CITY OF ALBUQUERQUE

October 23, 2017

Re: Pat Hurley Community Center, 3828 Rincon Rd. NW
Request for Certificate of Occupancy
Transportation Development Final Inspection
Architect's Stamp dated 04-01-16 (J11-D012)
Certification dated 10-18-17

AS102

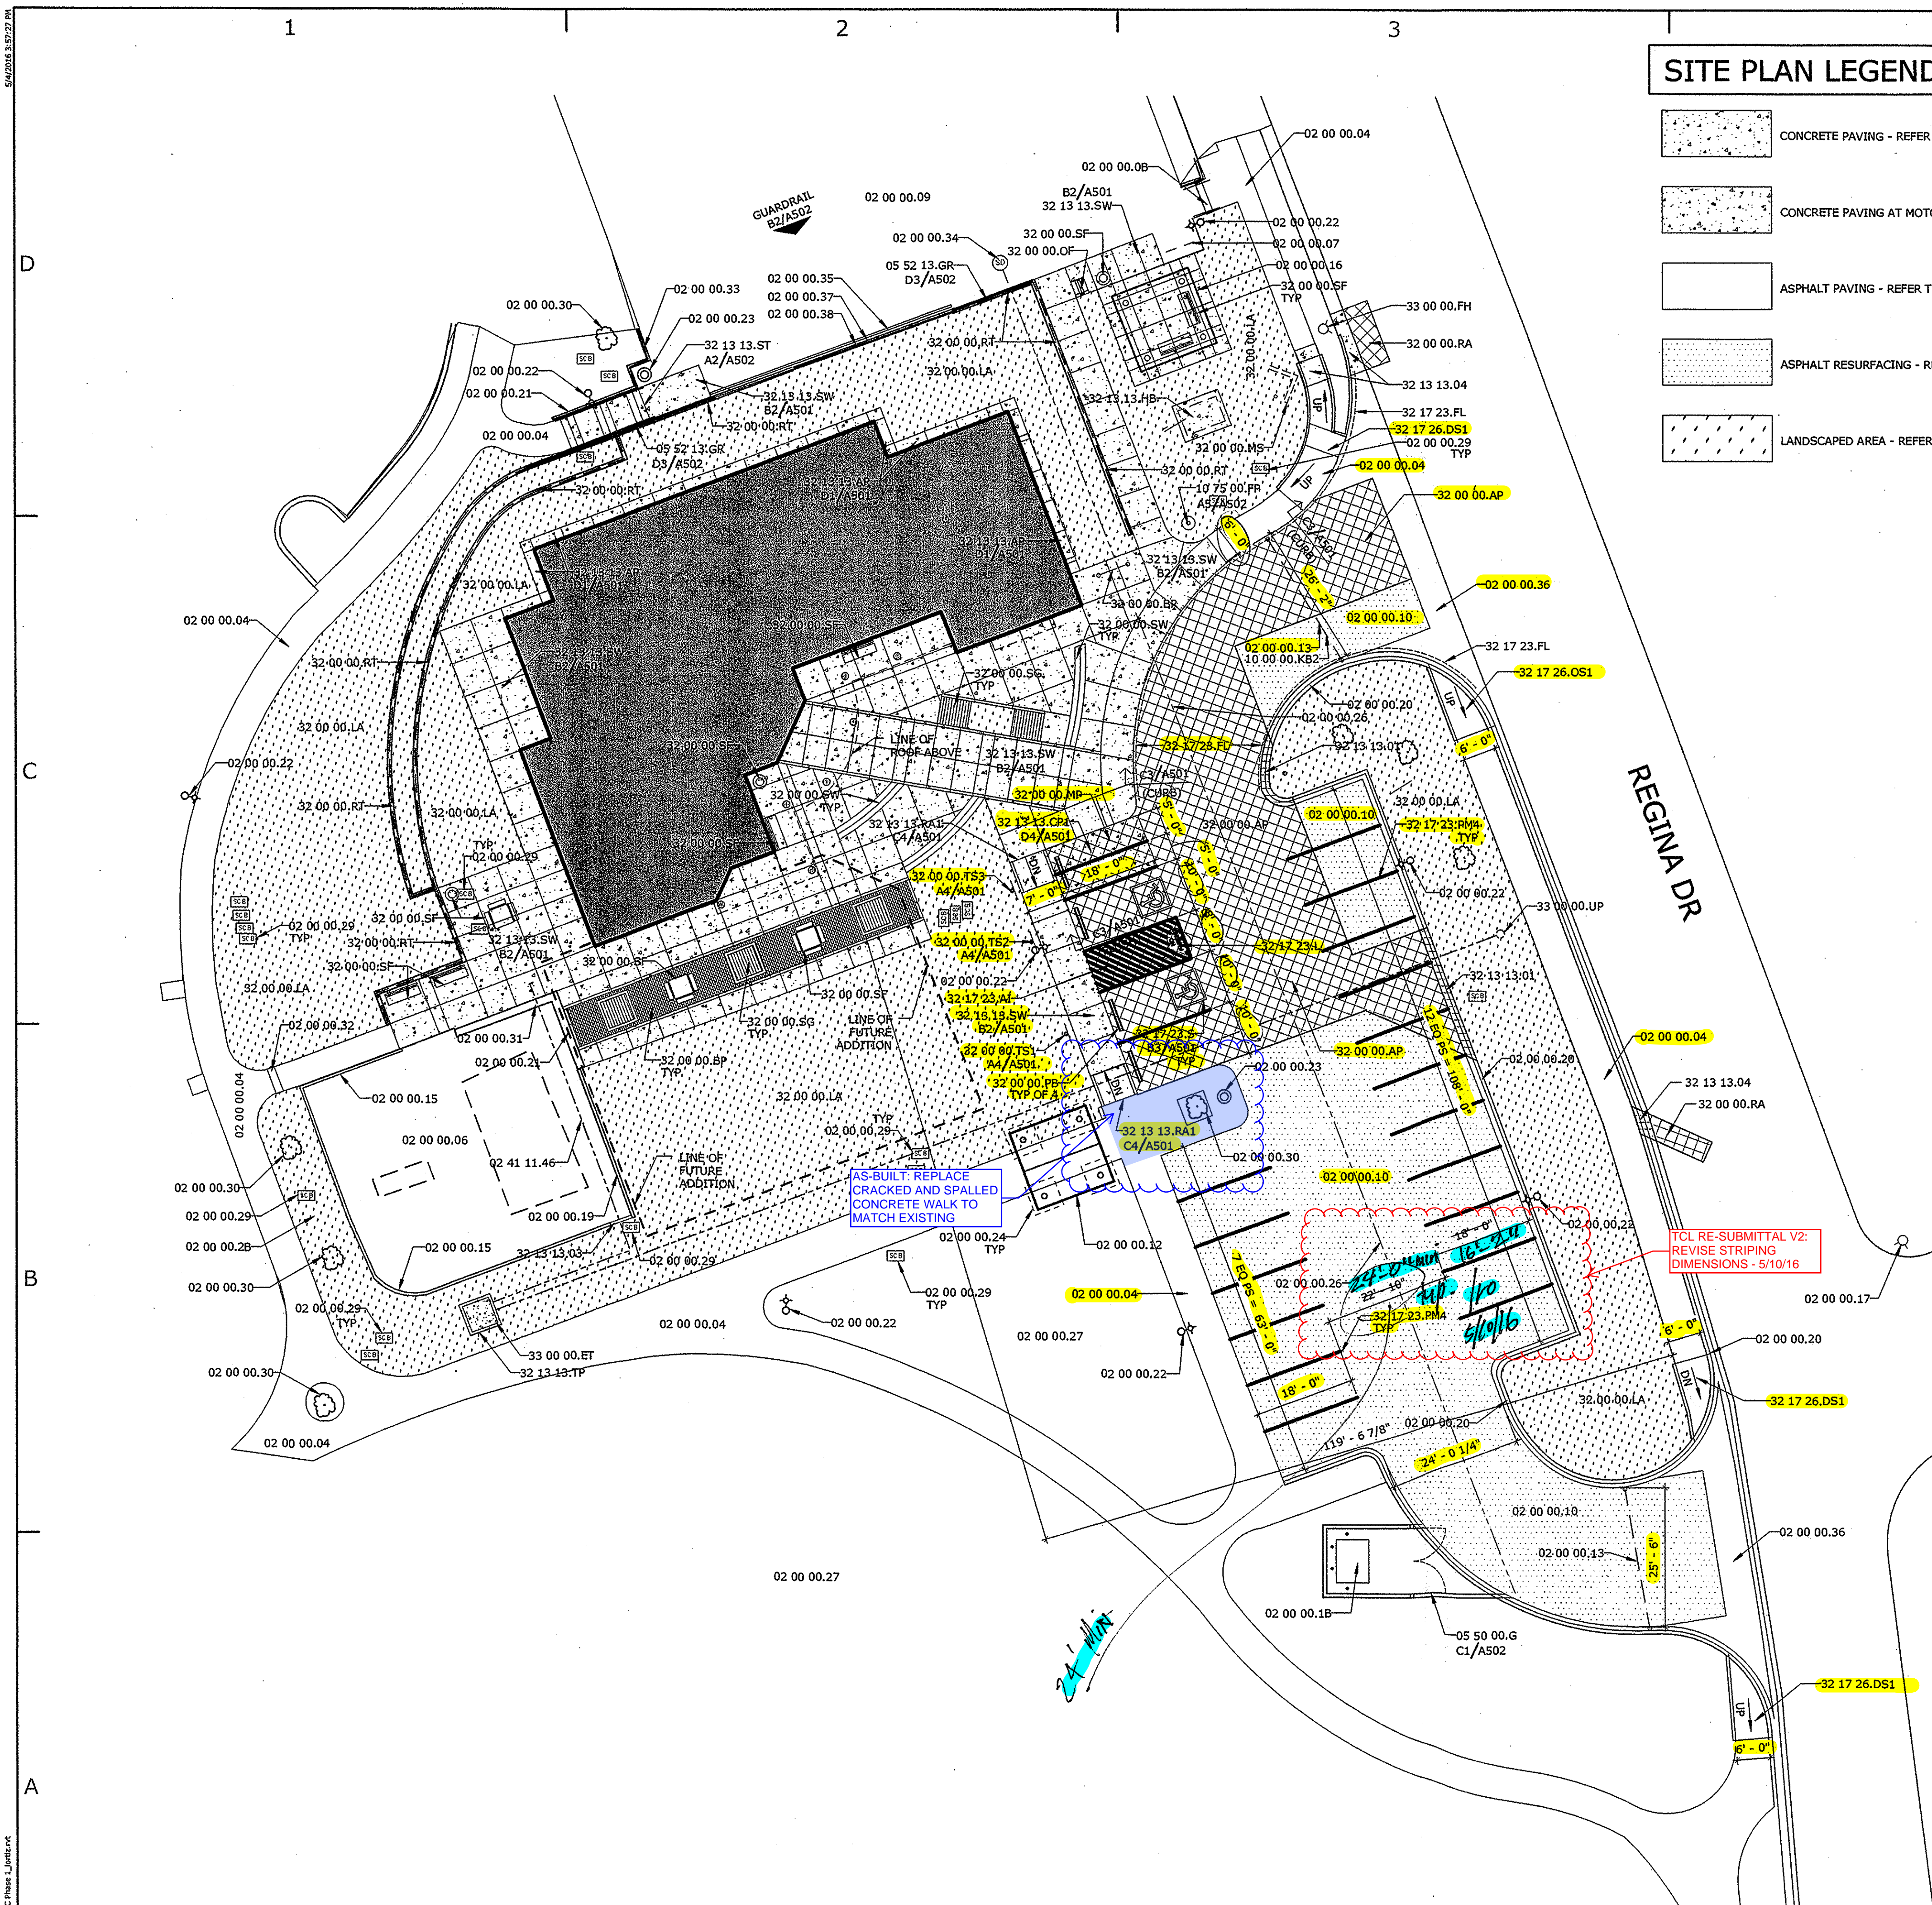
- Construction fencing must be removed from the parking lot.
- Gravel and dirt must be removed from the ADA Curb ramps. Picture attached.
